# Cumberland Council

9 August 2016

**SITE: DEXUS QUARRYWEST PROJECT (SSD 6801)**  
**SUBJECT: SSD 6801 MOD 2; S96 MODIFICATION FOR THE QUARRYWEST WAREHOUSES PROJECT, RECONCILLUATION ROAD, PEMULWAY**

Developable Lot B Plan

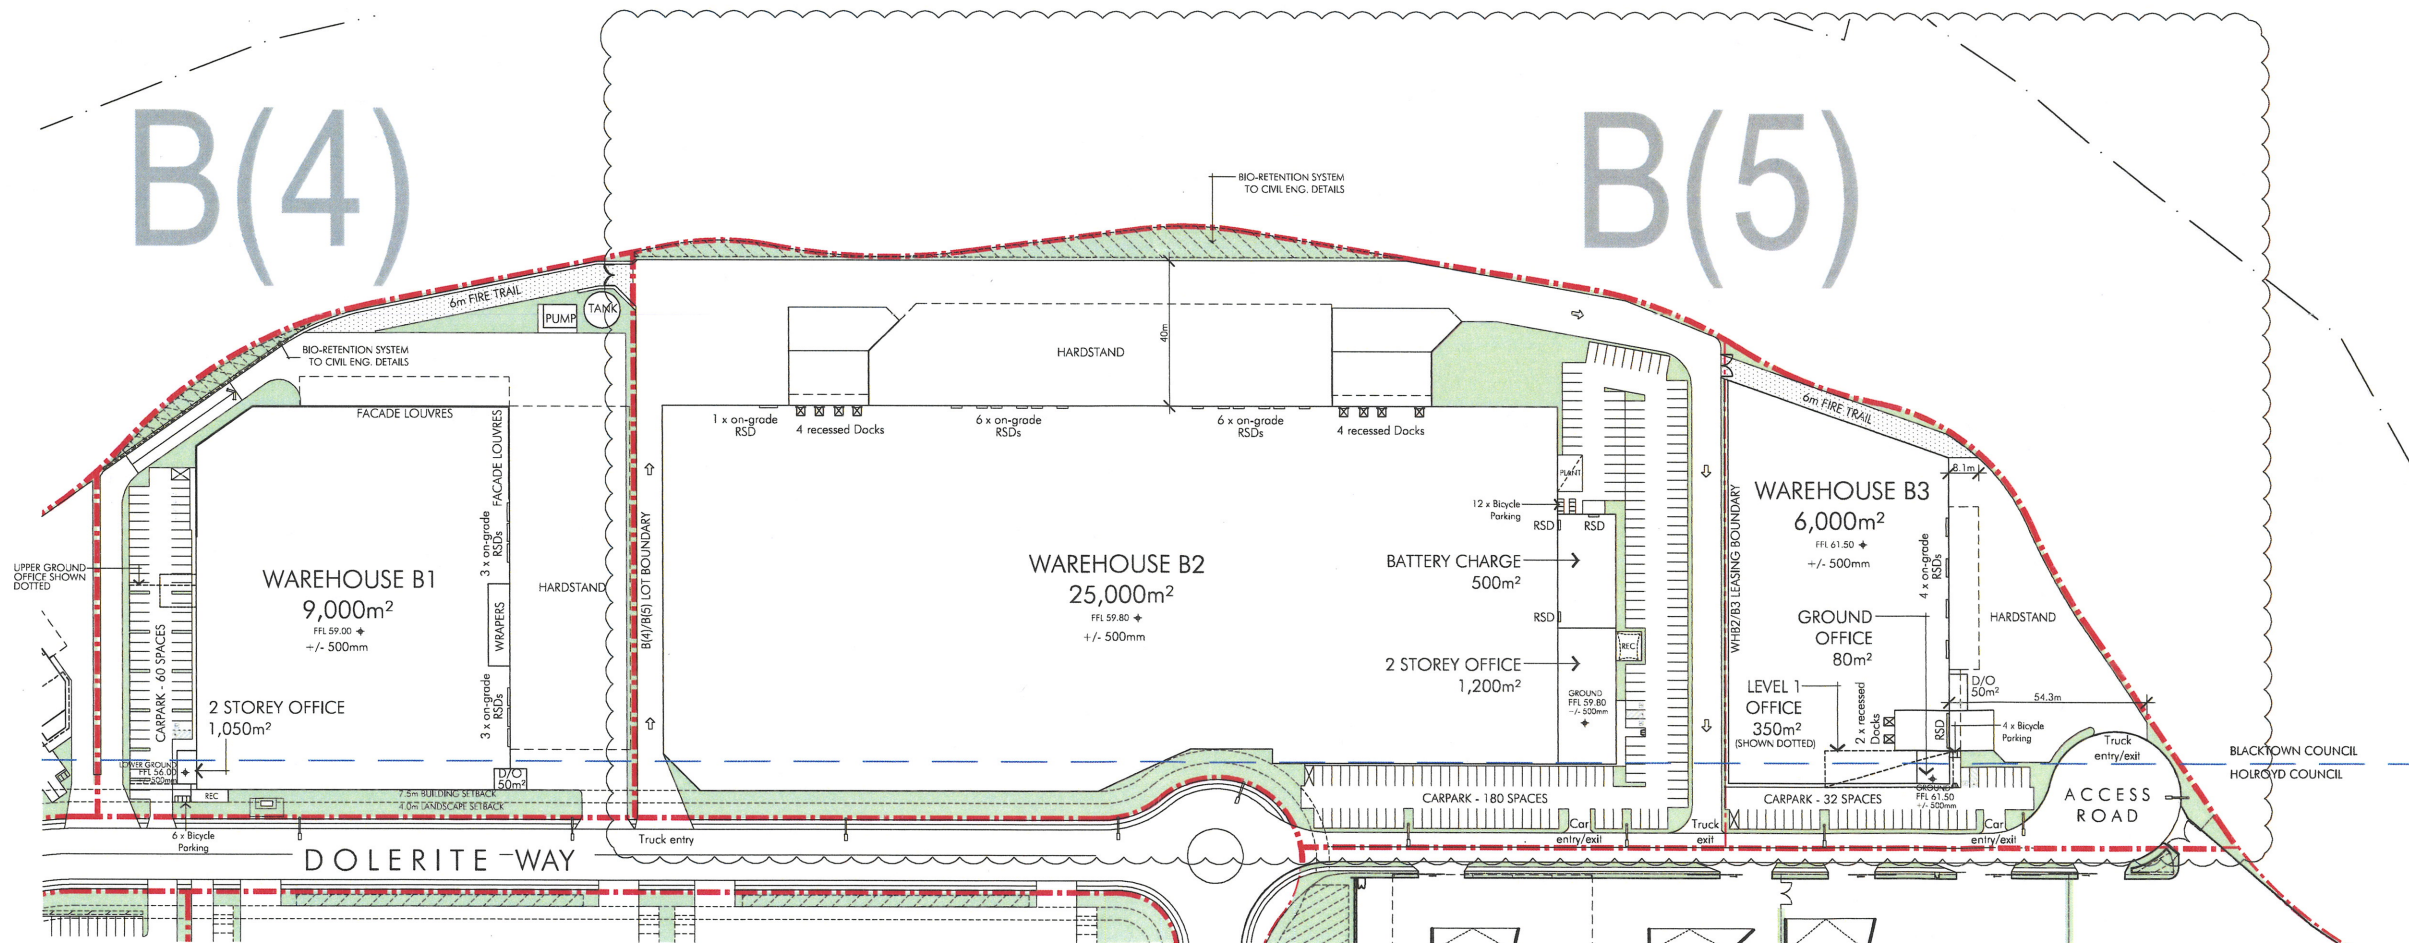
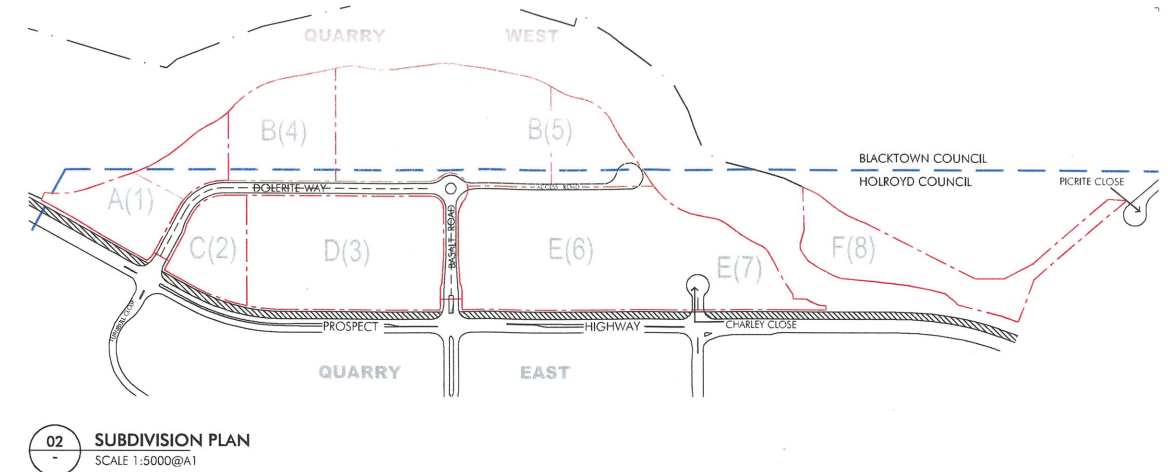
1. Dimension of all carparking spaces, access driveway, internal roadways, aisle widths and bicycle parking spaces shall be shown on the plans and be in accordance with AS 2890.1:2004, 2890.3:2015 & 2890.6:2009.
2. The gradients of the loading bays for warehouse B2 and B3 shall be shown on the plans and be in accordance with AS 2890.2:2002.
3. A swept path analysis shall be provided demonstrating the largest vehicle (heavy vehicle) can manoeuvre into the loading bays and exit the site in a forward direction.
4. Directional arrows for internal circulation shall be provided on the pavement on approaches to, and within, the carpark area and loading bays.
